April 30, 2015

**RE: Starbucks and Burger King, Tract 338-B, 1000 Rio Grande Blvd. SE
Grading and Drainage Plan
Engineer's Stamp Date 3-30-2015 (File: H13-D021)**

Based upon the information provided in your submittal received 4-01-15, the above referenced plan cannot be approved for Building Permit until the following comments are addressed:

1000 RIO GRANDE BLVD., NW GRADING AND DRAINAGE PLAN

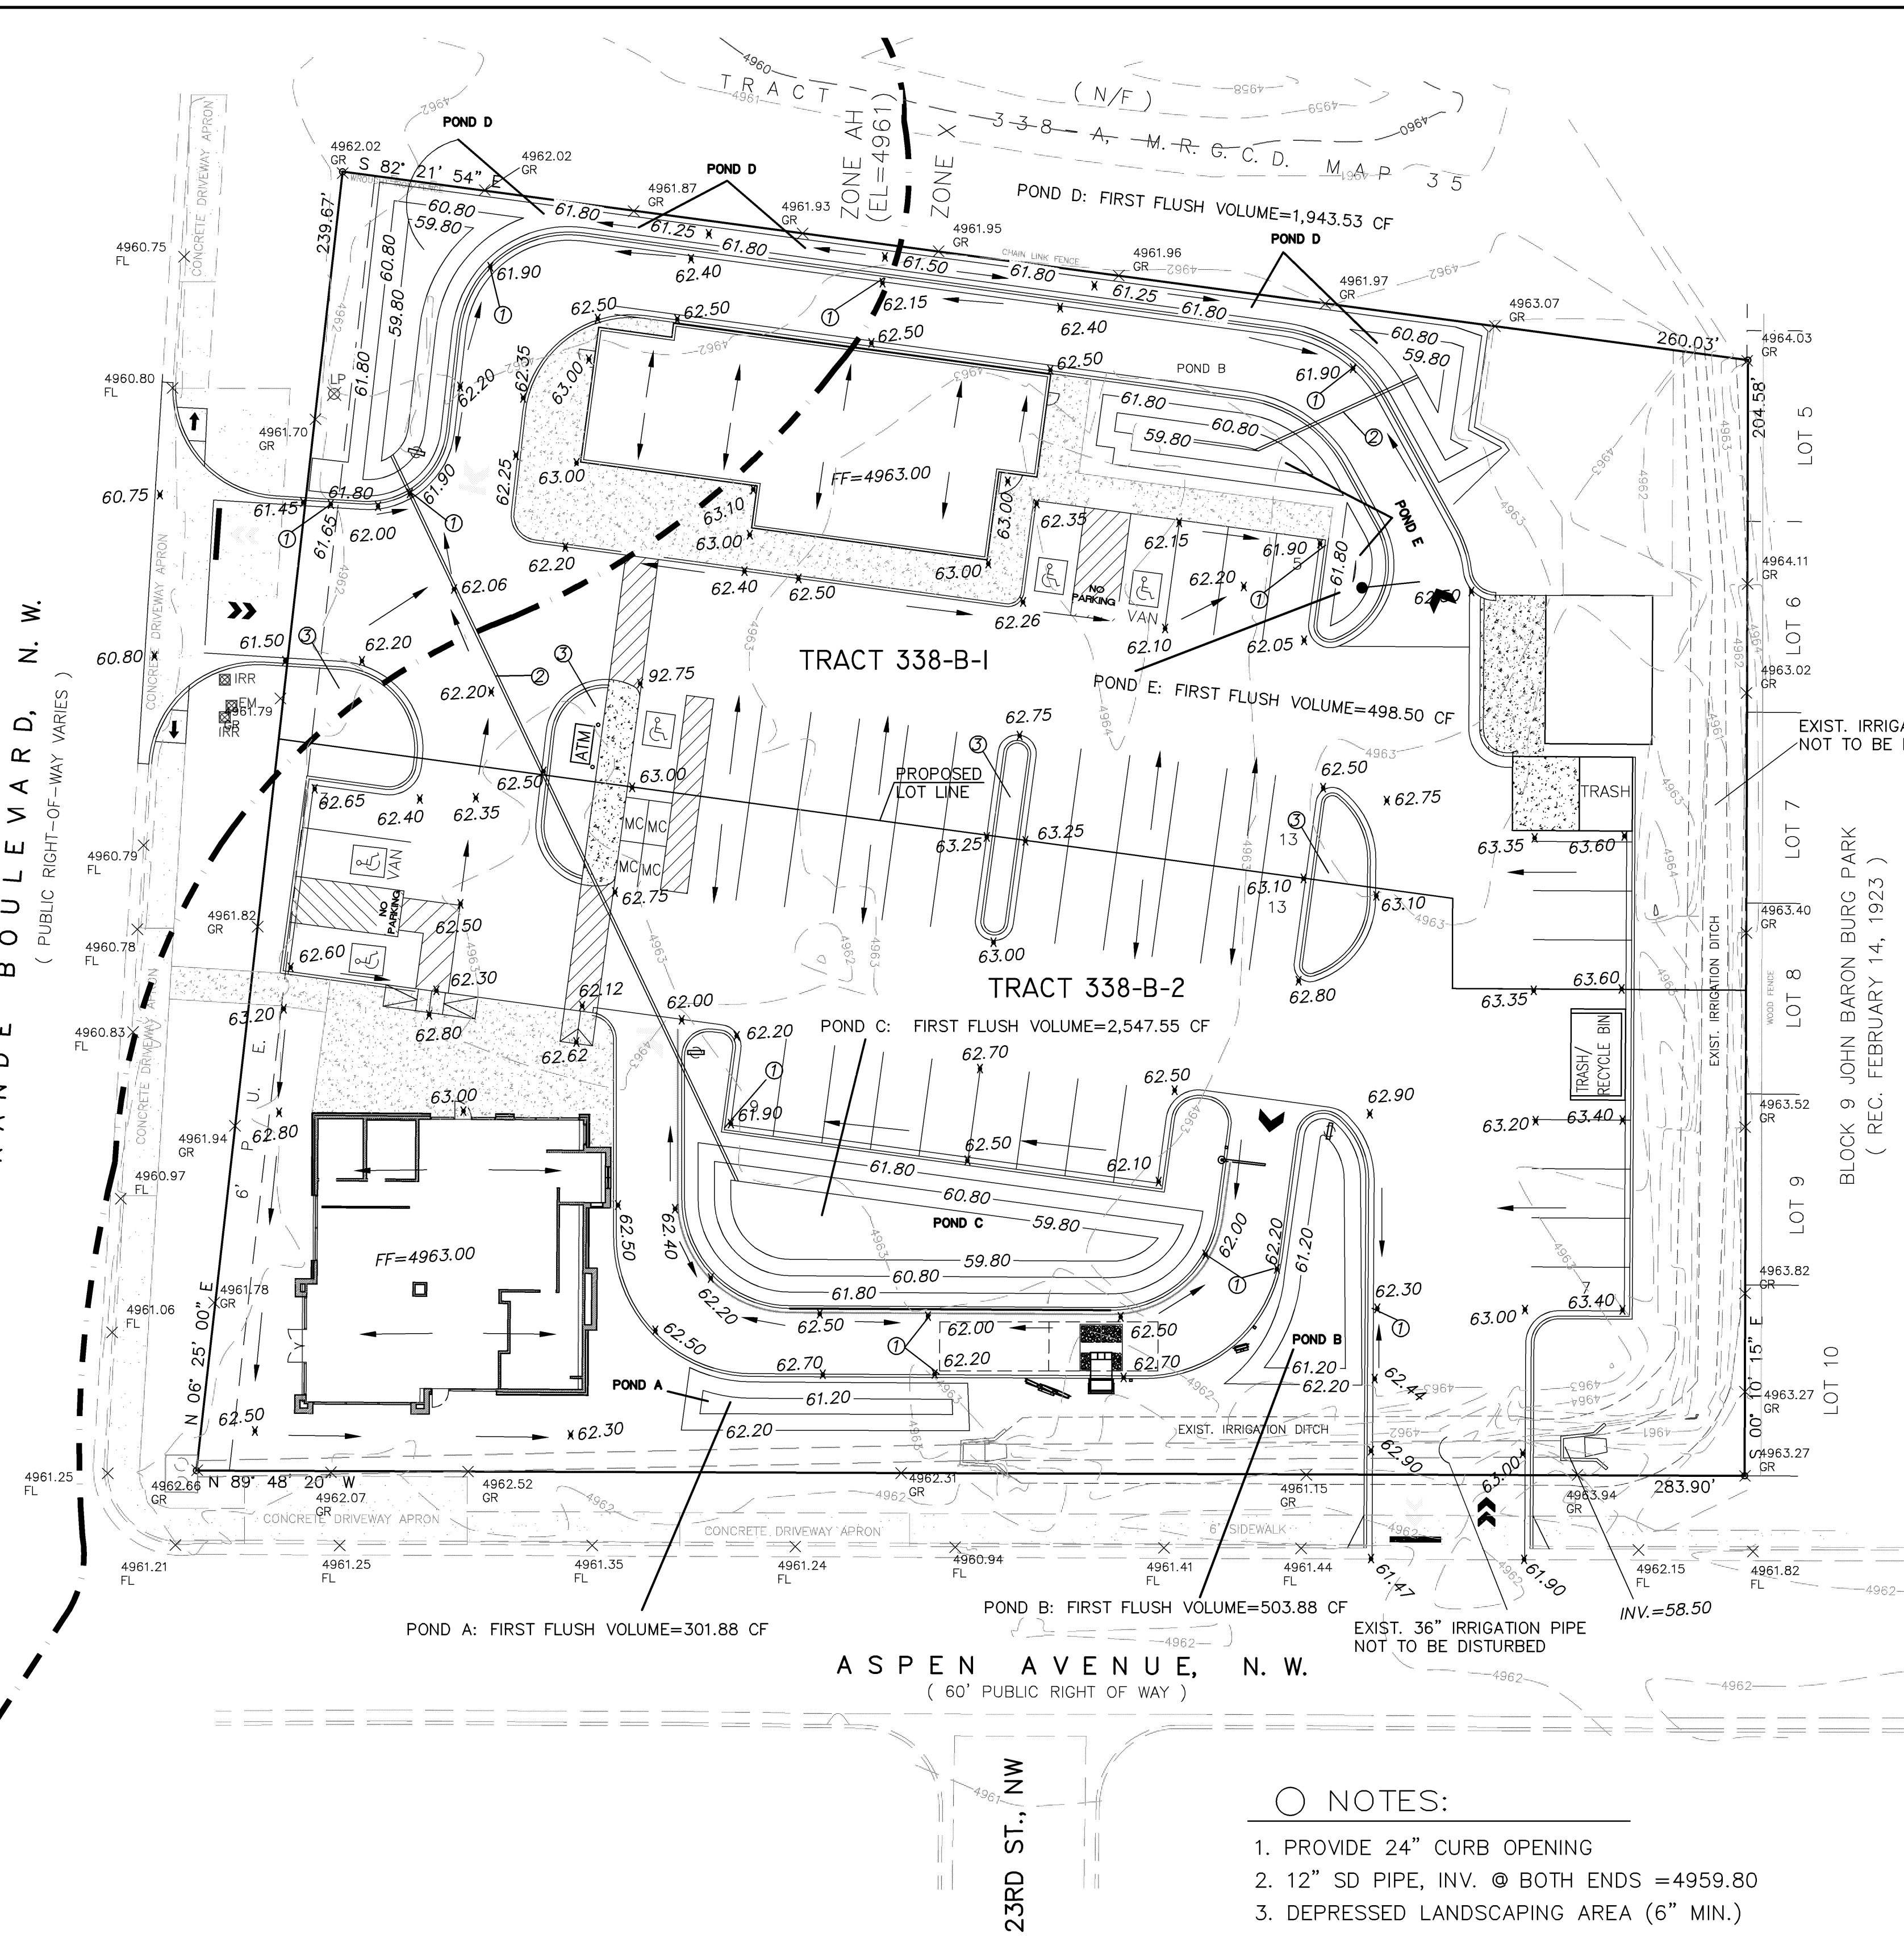
- 1) Provide a survey benchmark and existing spot elevations along the entire site perimeter. These are particularly important at the north and eastern boundaries. Also, provide existing curb elevations on Rio Grande Blvd.

- 2) A sidewalk culvert needs to be provided from Pond D to Rio Grande Blvd. Call out COA Std. Dwg. 2236 for the sidewalk culvert. In the valley, a maximum discharge rate of 2.75 cfs/acre from the site can be allowed, or ½ inches of runoff can be retained. It is preferable to discharge a rate of 2.75 cfs/acre from the site.

- 3) Indicate the floodplain boundary in the legend. Because you are constructing in the floodzone, please request a floodplain permit. An elevation certificate must be provided prior to Certificate of Occupancy. Additionally, for any fill you are bringing into the floodplain area, a compensatory volume of excavation must be provided. Please discuss how you are addressing this in the write-up.

- 4) If the pipe between Ponds D and C is meant to be an equalizer pipe, a larger size of pipe than 6" would be recommended. Explain the pipe's capacity to function as an equalizer pipe. Also, provide invert elevations at all on-site pipes.

- 5) Show the direction that the roofs drain. Indicate which ponds are retaining the first flush pond volume and note it on the plan view along with the first flush volume per pond.

6) Show the existing pipe and pipe size for the irrigation pipe under the new driveway to Aspen Avenue to demonstrate adequate pipe cover. Have a note for the irrigation ditch facilities to remain undisturbed.

7) Provide capacity calculations for the proposed sidewalk culvert and on-site curb cuts. The scale on the plans is shown as 1:10, but it appears to be 1:20. Revise as needed.

8) It is not desirable to have a curb cut close to the north boundary of the site where it is too close to the property adjacent to the north. Is much of the roof draining to the north for the northern building? Could this flow be directed to the western side of the site where it is closer to the outfall and have a larger curb cut provided? In the write-up, discuss the impact of the on-site improvements to the property to the north or lack thereof.

10) Provide more spot elevations for the swale along the north side of the site and within the drive-thru between Pond D and E. The 92.75 elevation shown within the parking lot at the corner of one of the handicapped parking spaces is in error.

11) Provide the total for the pond volumes under the pond volume calculations at the bottom of the sheet. The summation of the pond volumes provided does not equal the pond volume calculations in the write-up. Take the language about draining to inlets out of the write-up if the site is not draining to any inlets. In the narrative for the "Existing Drainage Conditions", include a statement about historical flow patterns.
